**Planning Officer:** Zac Denton  
**Planning Application Ref:** AW/192/18/T  
**Location:** 6 Larchfield Close, Aldwick  
**Description of works:** Fell 1No. Silver Maple  
**Reasons Given:** Health and Safety  
**Comments on Application:**

**Silver maple** *Acer saccharinum* Approx. Height: 13m Average Spread: 4m Age: Mature

REF 1

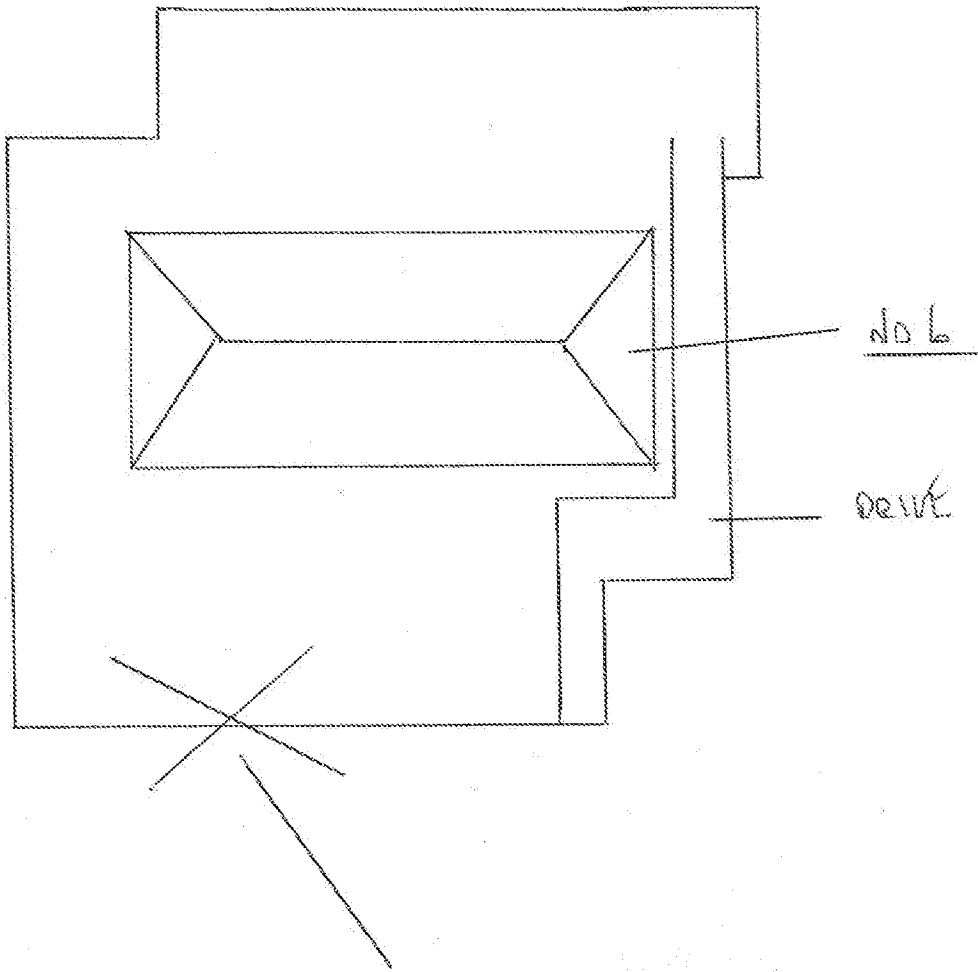
- Visible from several neighbouring properties and road providing 'no through' access to residential dwellings.
- Multi stemmed with compression at unions, one of which has expired and presents a large region of sunken bark. This presents an unacceptable level of risk of harm to persons and property.
- The tree appears otherwise to be in a fine physiological state, with a full and healthy crown arising from the other stems.

- The risk of catastrophic stem failure which exists is unacceptable for this location. Its removal will leave a heavily asymmetric crown and diminished aesthetic value. Due to the limb and branch configuration and bio-mechanical characteristics of this species, there are no satisfactory remedial pruning options.
- The unfortunate but necessary removal of such a large amount of high canopy will need to be compensated for by way of replacement tree planting.

- I recommend **APPROVAL** for this application subject to the planting of a replacement tree.

- Once the tree has been felled (and either grubbed or ground out) then a replacement tree is to be planted in the same place or nearby to within 20metres along the property frontage and no more than 4m from its front boundary.

This is to be of Standard Nursery Stock proportions (10-12cm girth & 2m to 3m overall height) supported on a 'short stake' system with appropriate securing ties and pads.

It is to be planted within 12 months of the removal of the silver maple tree.
